Tracy Bellamy - 3rd Track Objection

Please find attached my objection to the construction of a 3rd rail track between Thornleigh and Epping. This will severely impact the village atmosphere of Beecroft and is unnecessary.

Epping to Thornleigh Third Track Proposal. Application number SSI 5132.

Figure S.6 Cross-section and elevation - New Cheltenham Station concourse building (see also S.5 for artist's impression)

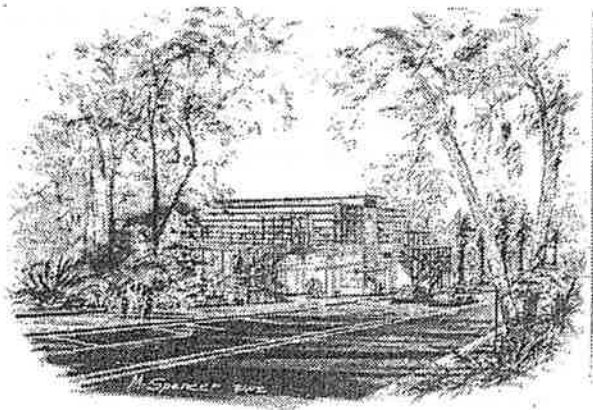
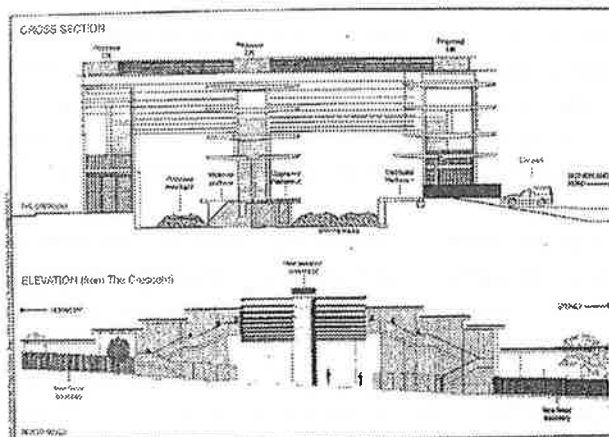
- The proposed redevelopment of Cheltenham Station shows no regard for the HCA. The visual impact of the proposed 13m high glass and steel concourse is totally unacceptable in this HCA.

Figure 5.3 Future Cheltenham Station layout

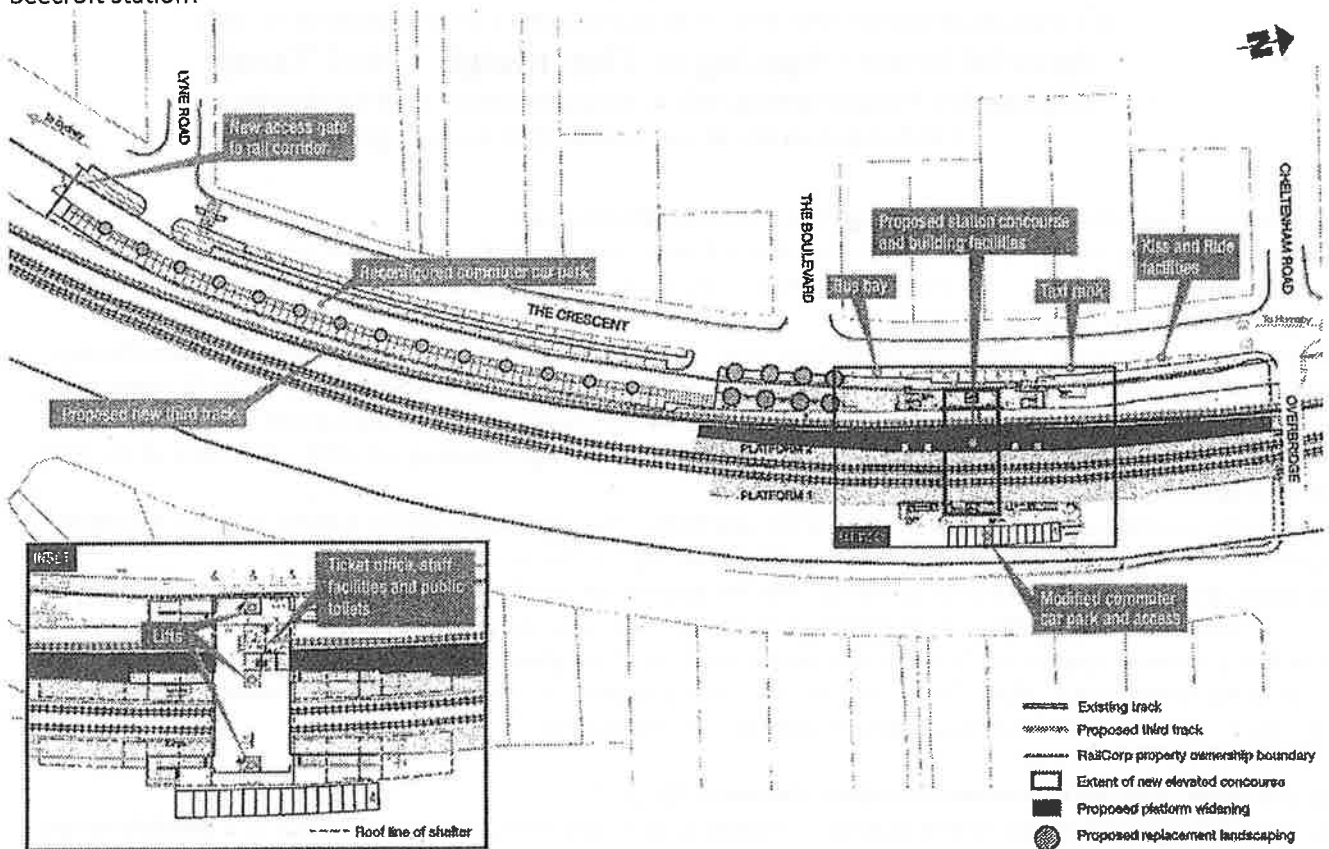
- There has been inadequate assessment of the project's impact on the fabric of the Beecroft Cheltenham Heritage Conservation Area (HCA).
- The plan given for Beecroft Railway station Precinct is vague. The relationship to the trees, playground and original 1895 platform located south of the present station is not shown. A fourth track is shown on the eastern side. The plan does not include urgently needed lifts to allow disabled access at Beecroft Station.
